**Town of Addison
Summary of Engineering Revision Comments**

Development: Galaxy FBO

Town Project #:19-09D

Town of Addison Engineering Review Conditional Civil Approval

SHEET NUMBER
C10.05

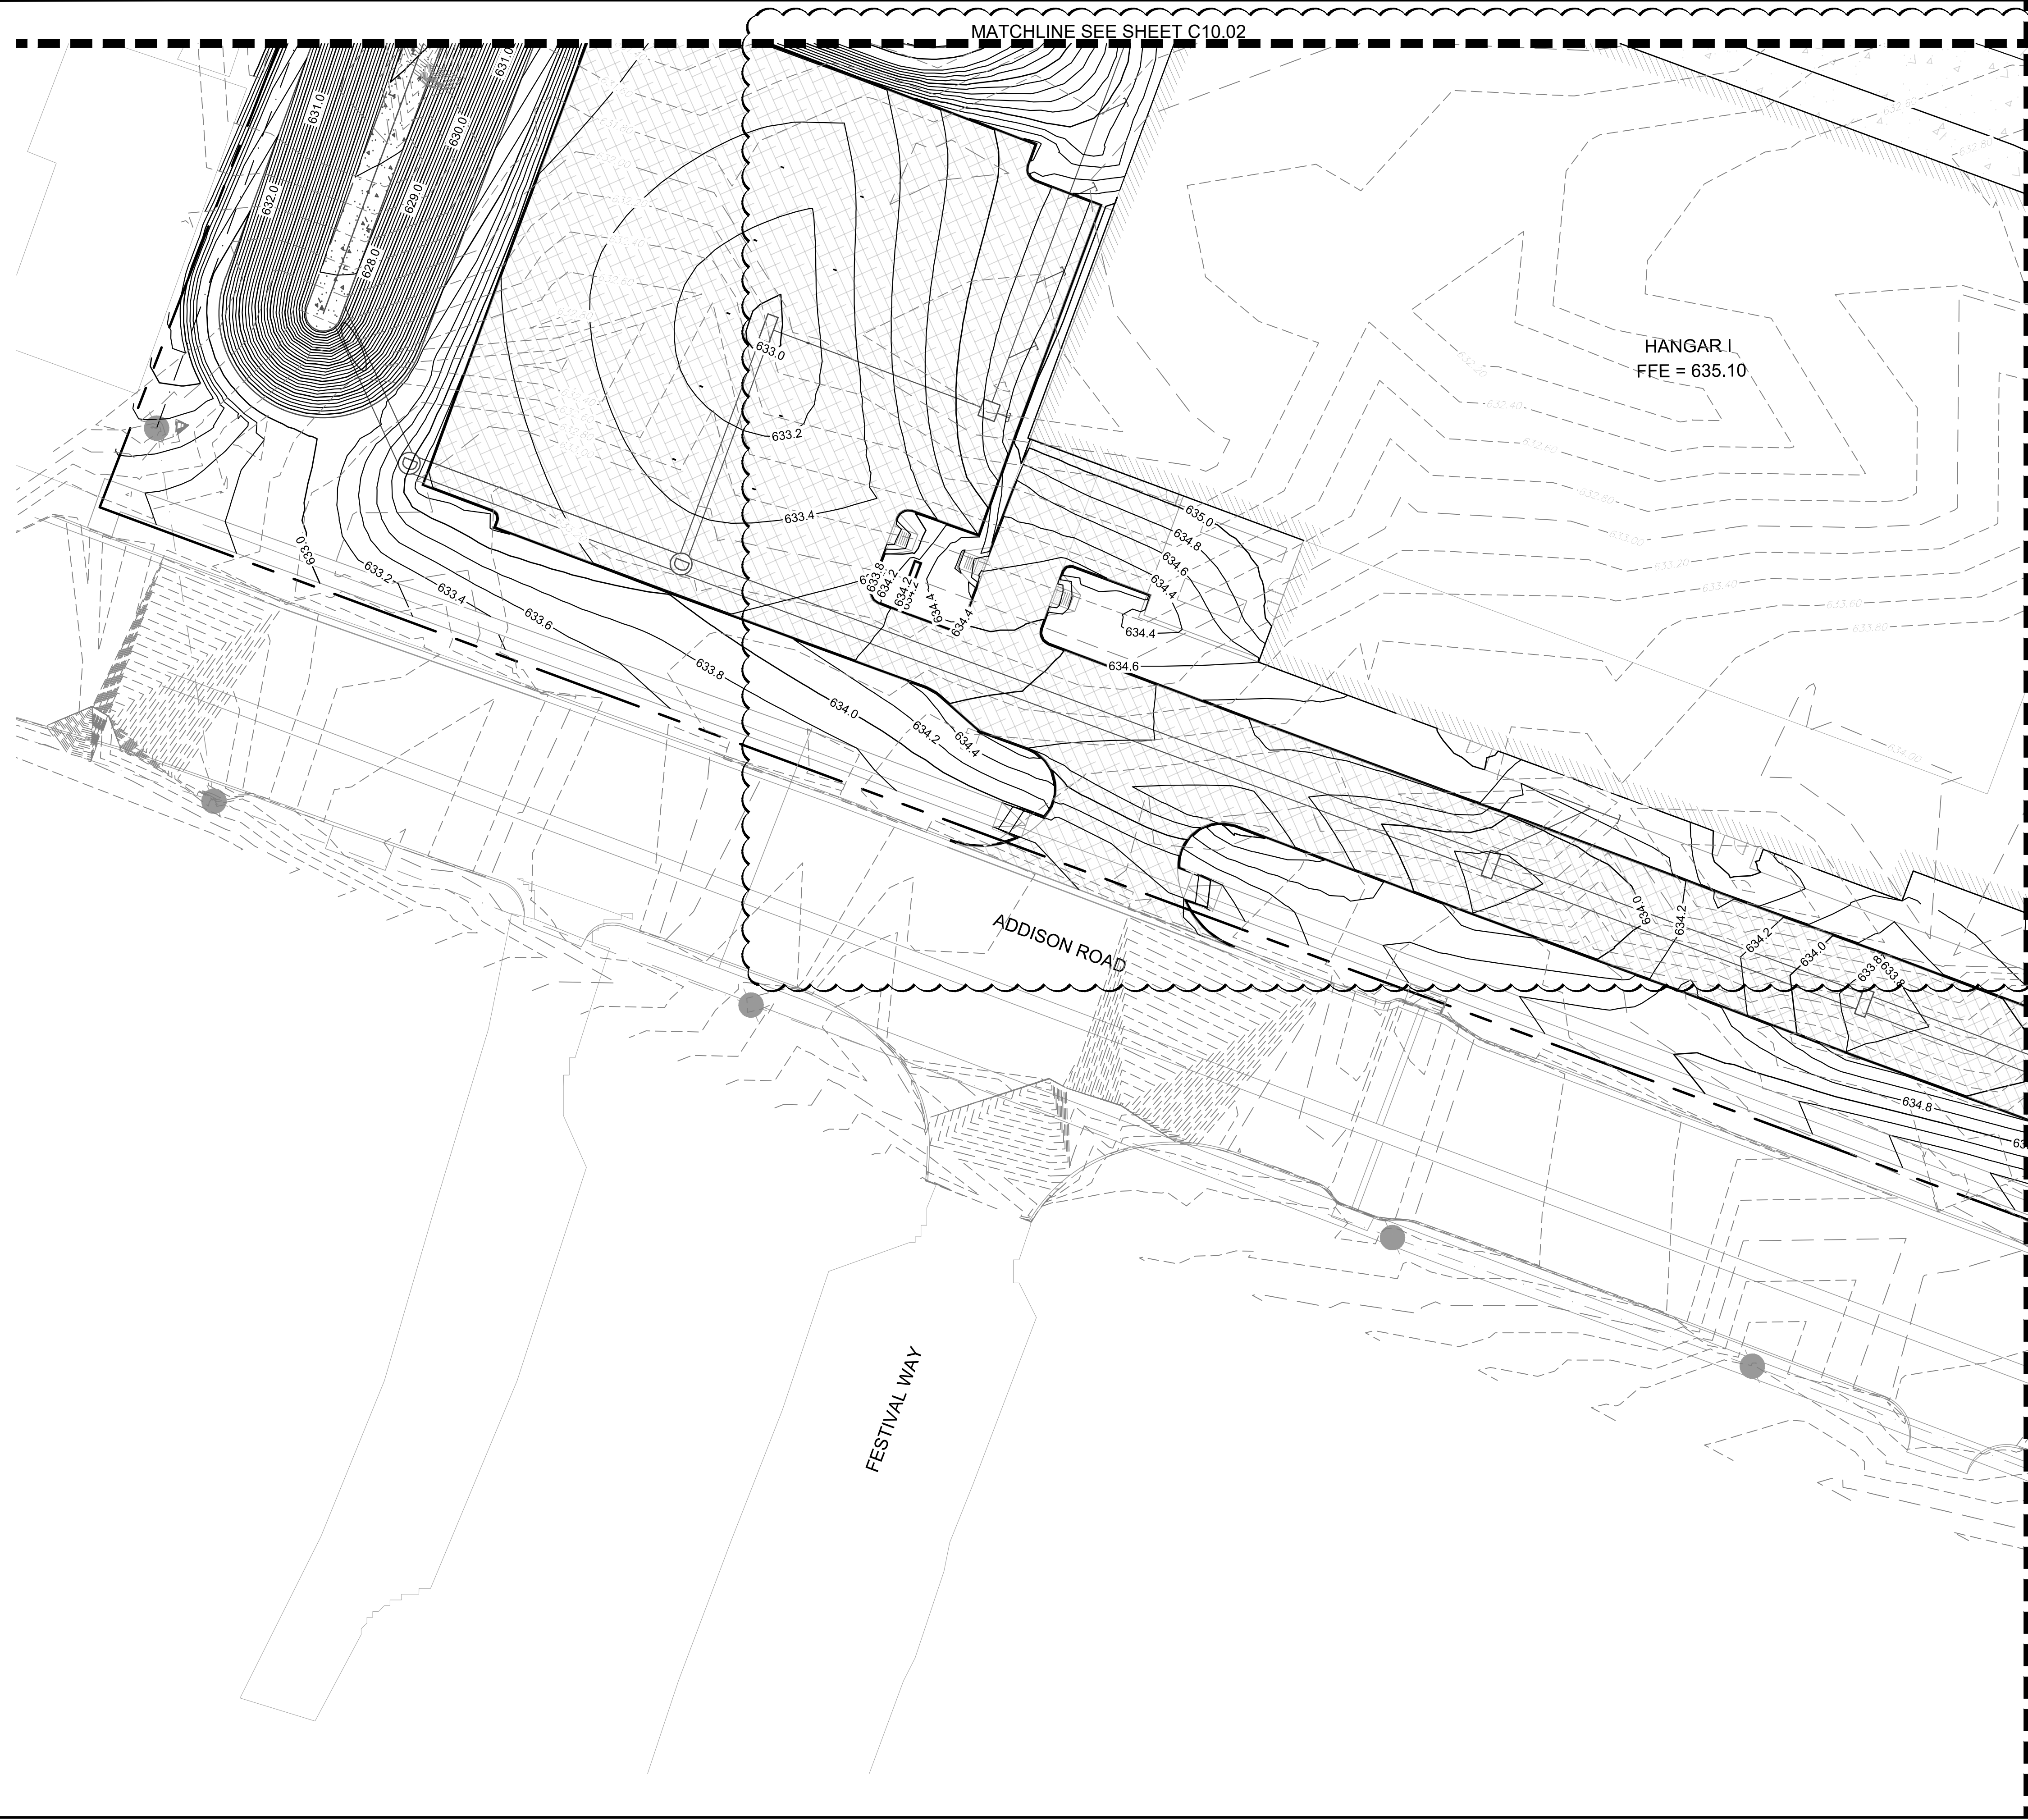
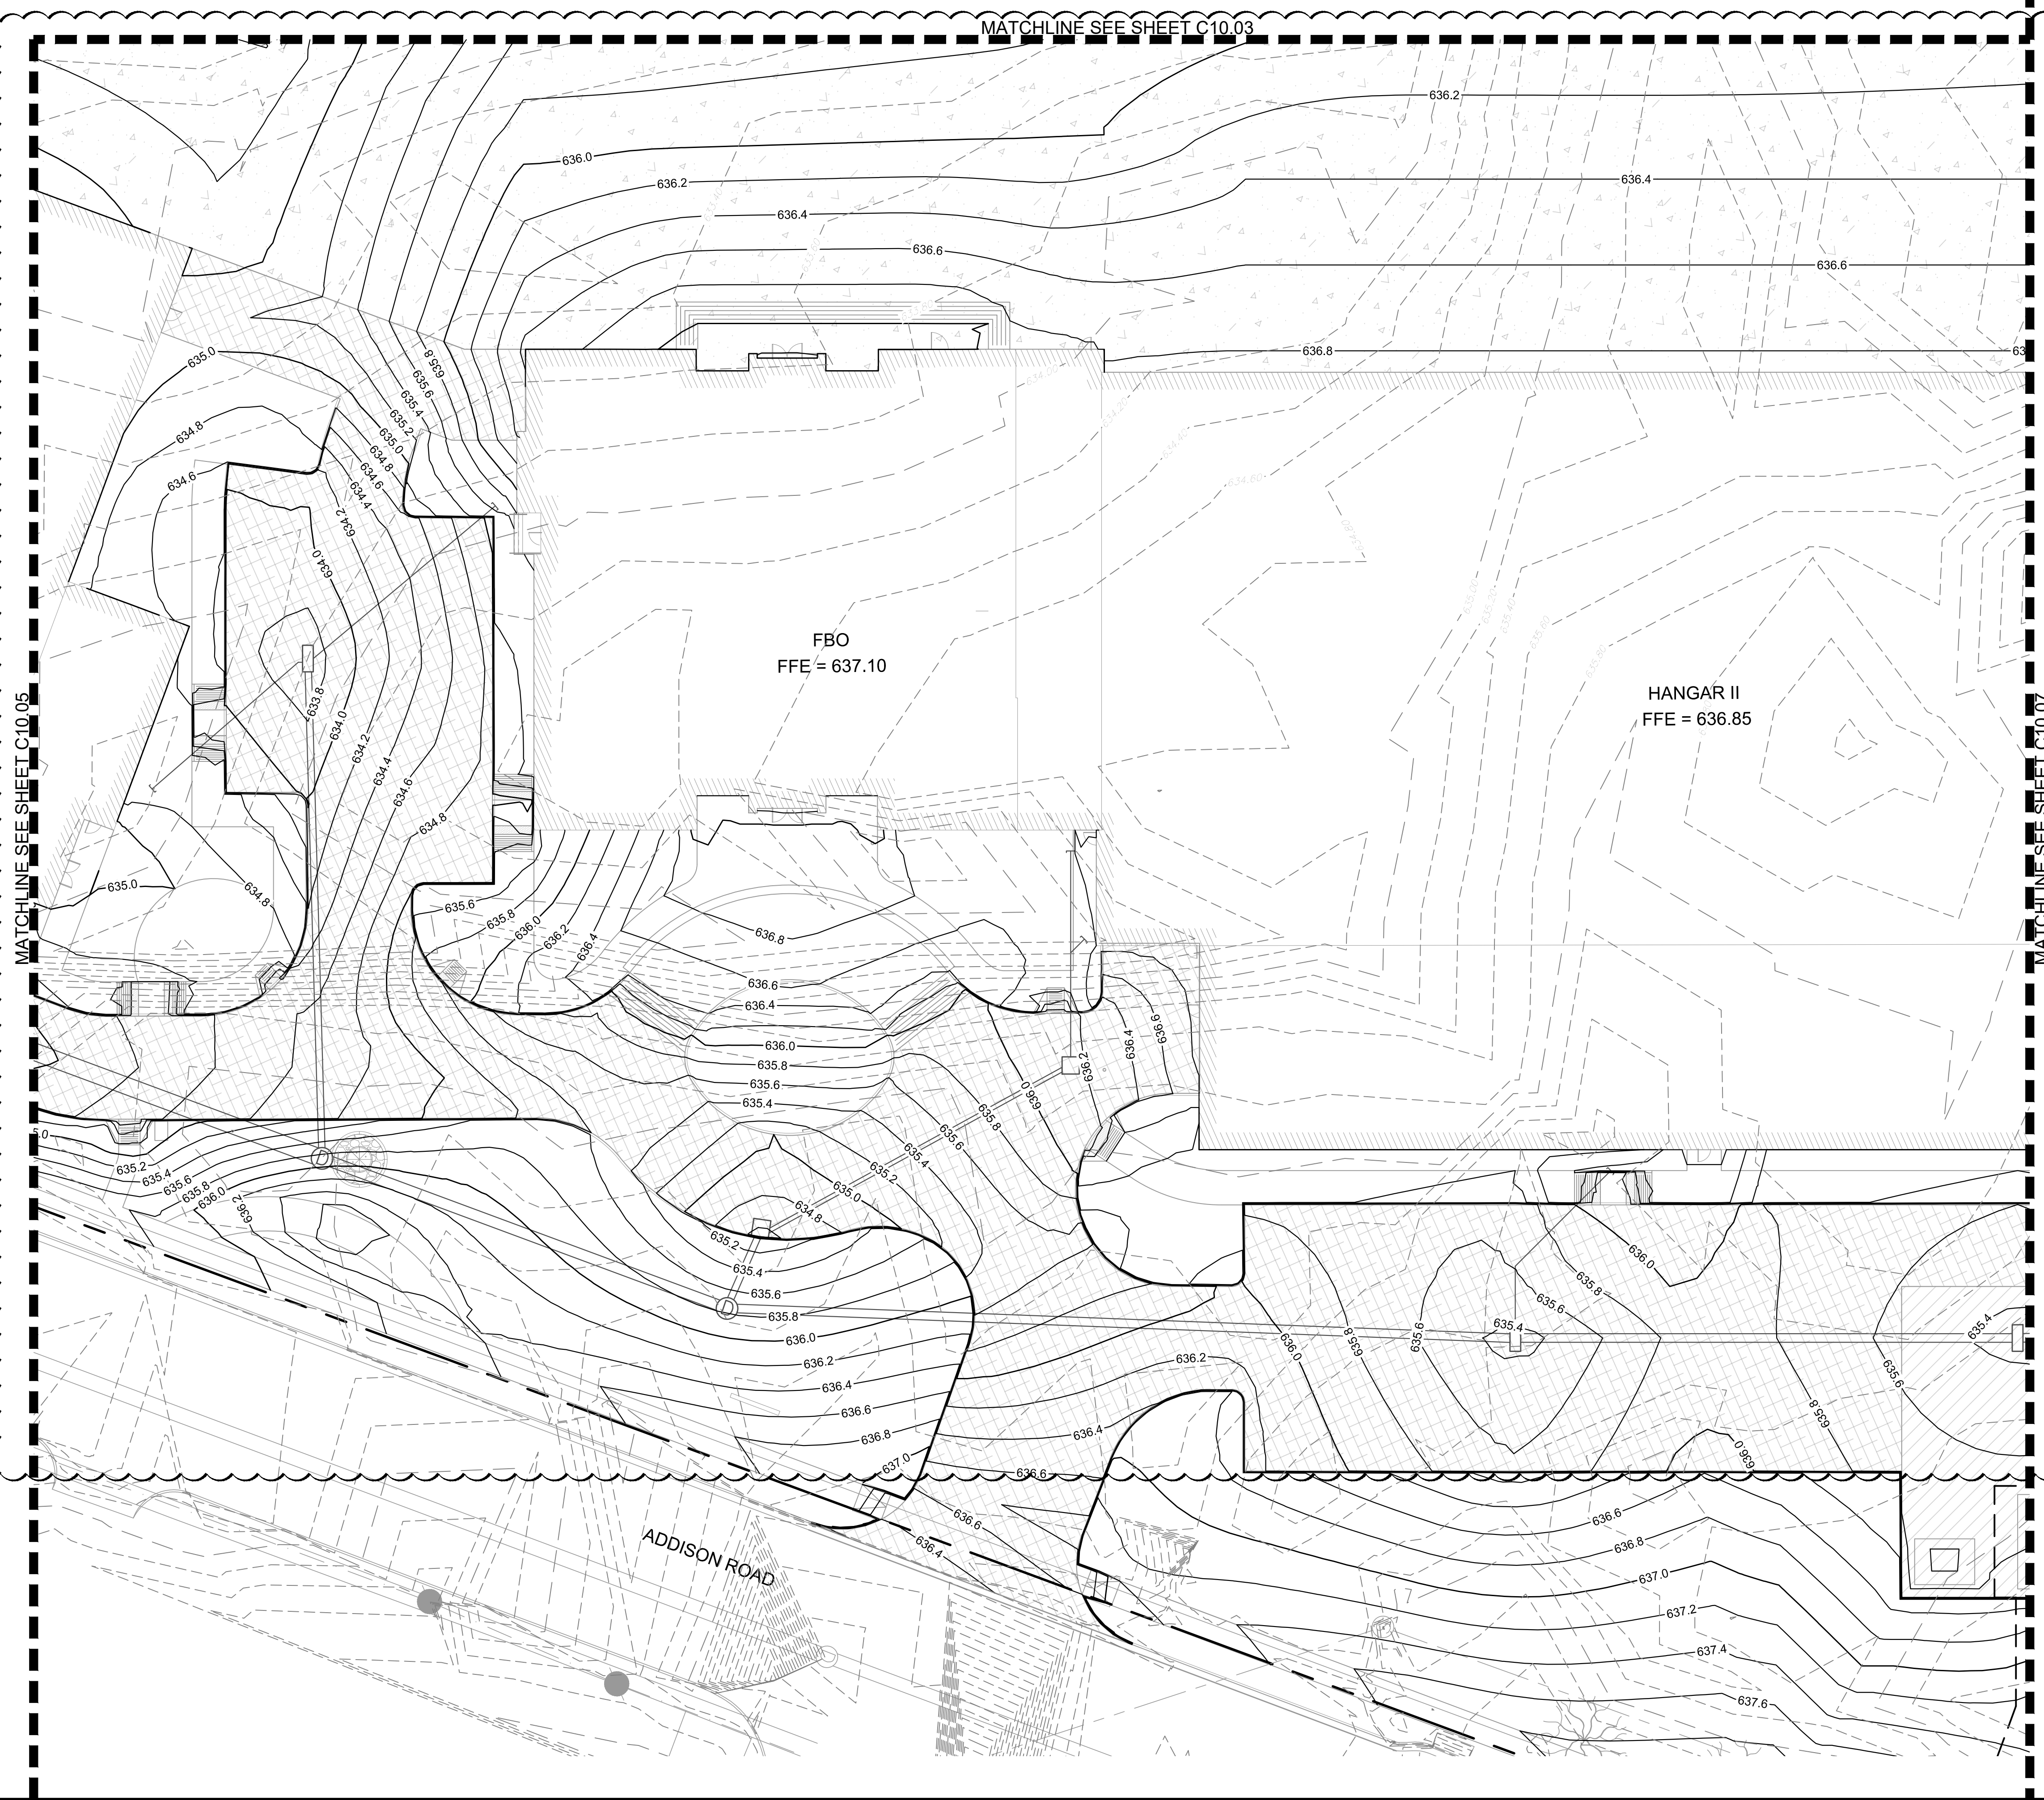
ASI-C006	10/30/2020	C10.04	Updated grading per field conditions verified by a construction progress topographic survey.	
ASI-C006	10/30/2020	C10.05	Updated grading per field conditions verified by a construction progress topographic survey.	
ASI-C006	10/30/2020	C10.06	Updated grading per field conditions verified by a construction progress topographic survey.	
ASI-C006	10/30/2020	C10.07	Updated grading per field conditions verified by a construction progress topographic survey.	
ASI-C006	10/30/2020	C10.08	Updated grading per field conditions verified by a construction progress topographic survey.	
ASI-C006	10/30/2020	C12.02	Updated rim and top of grate elevations on storm structures per field conditions verified by a construction progress topographic survey.	
ASI-C006	10/30/2020	C12.03	Updated rim and top of grate elevations on storm structures per field conditions verified by a construction progress topographic survey.
